Our Ref: A/112/12/

Rear decking and fencing to form outside seating area
Lamb Inn The Square Angmering Littlehampton

Thank you for your internet representation made on 13th December 2012 which has been recorded as '**no objection**' with the comments as follows:

| DRAWING NUMBER | 11045/R.PATIO R1      |    |          |

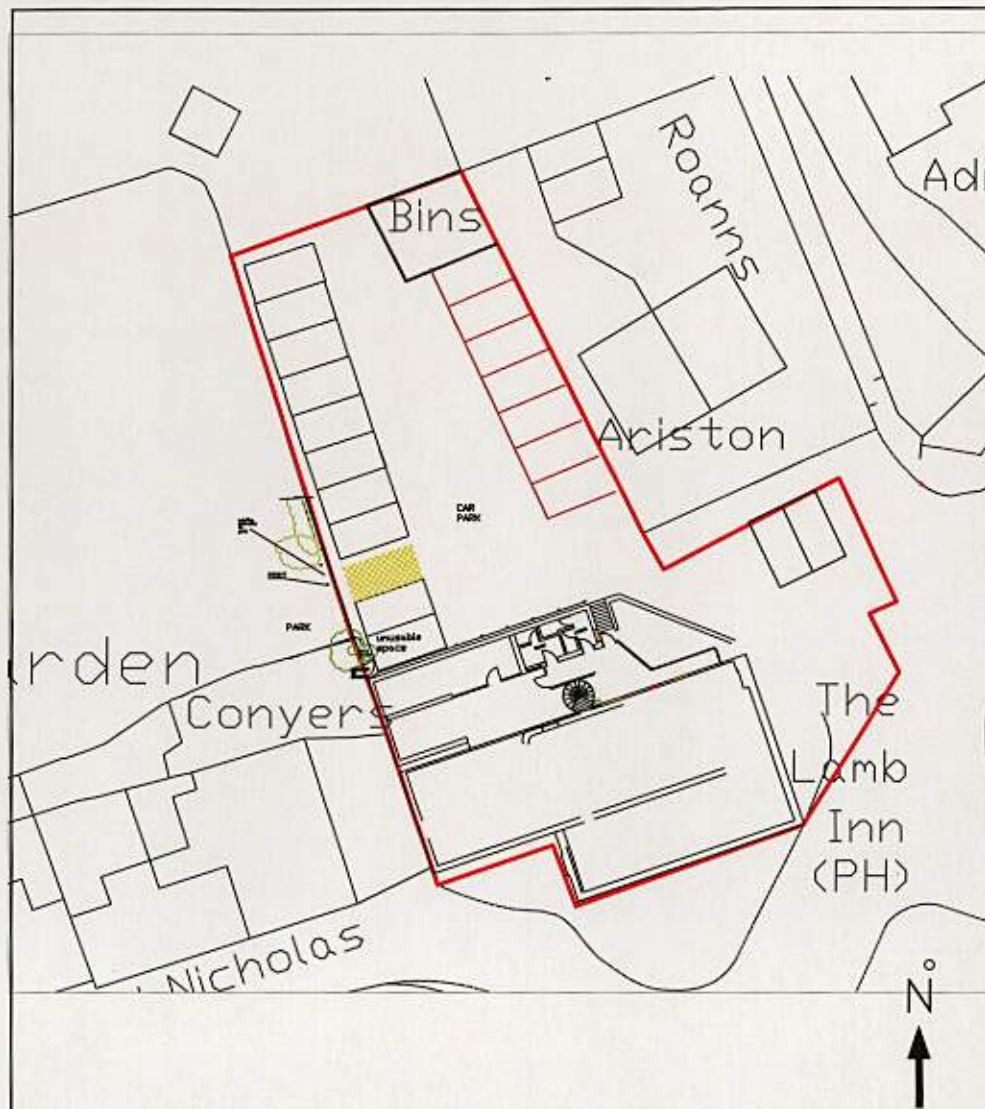
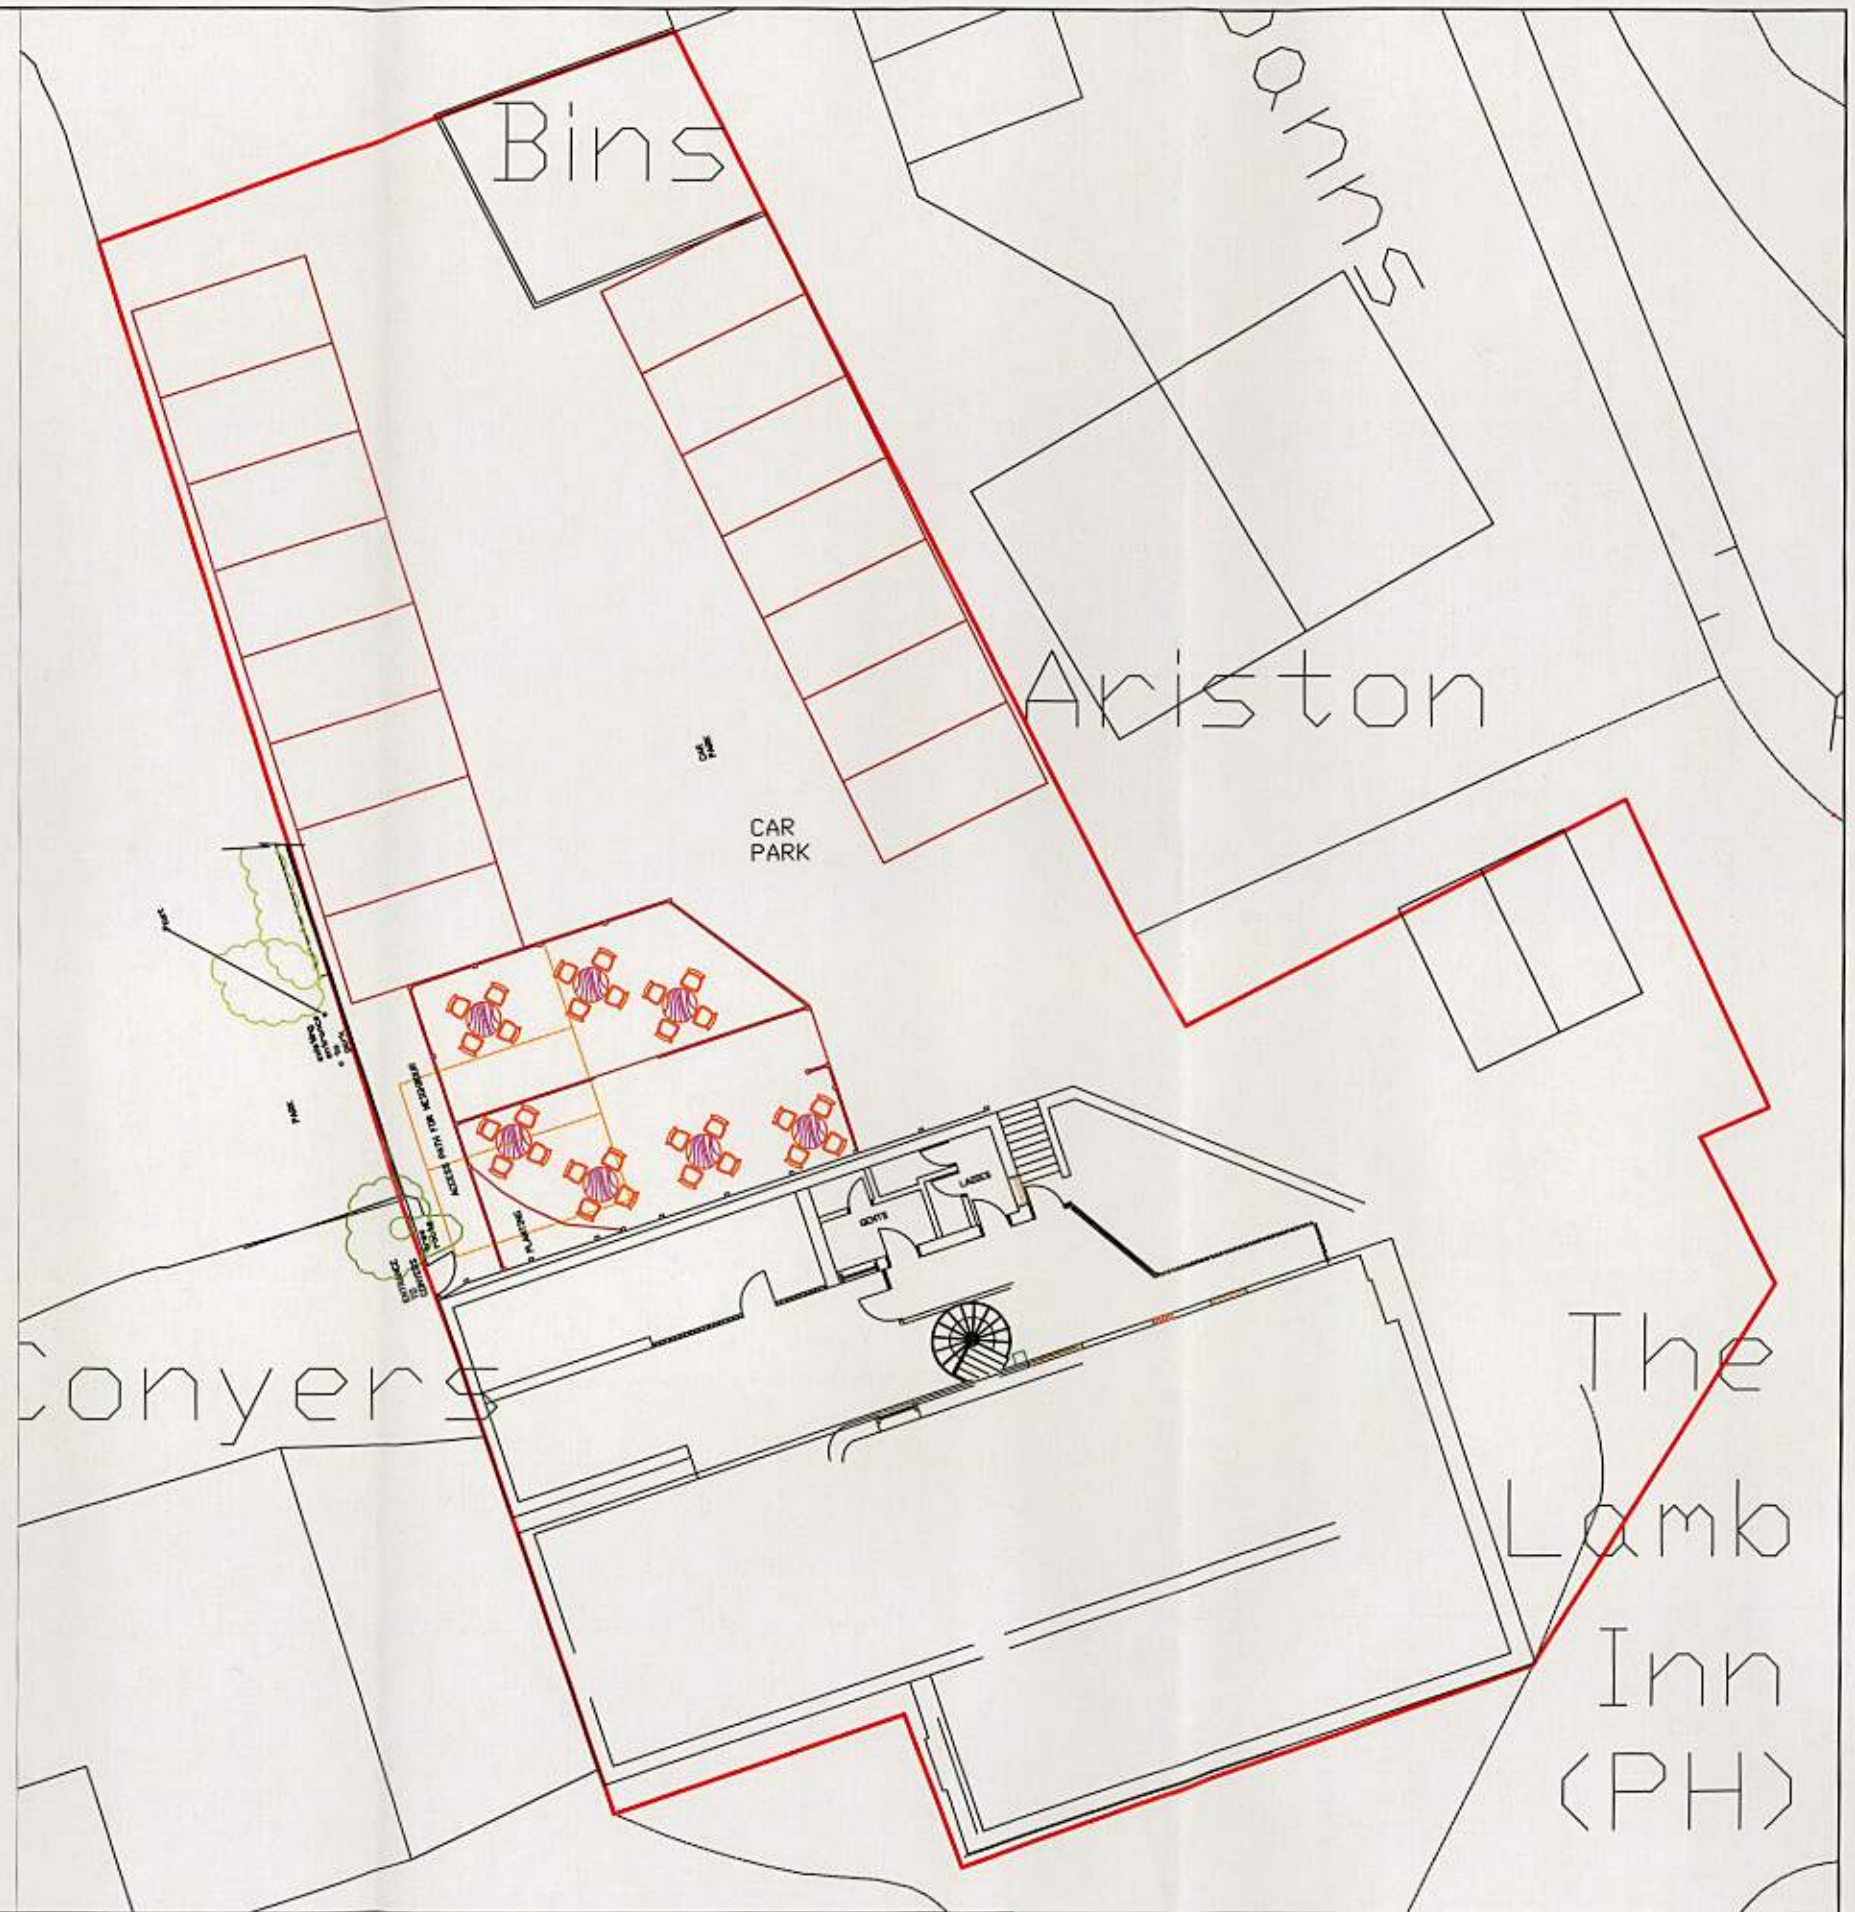
No objection. The gap between the fencing and first parking is to be sufficient.
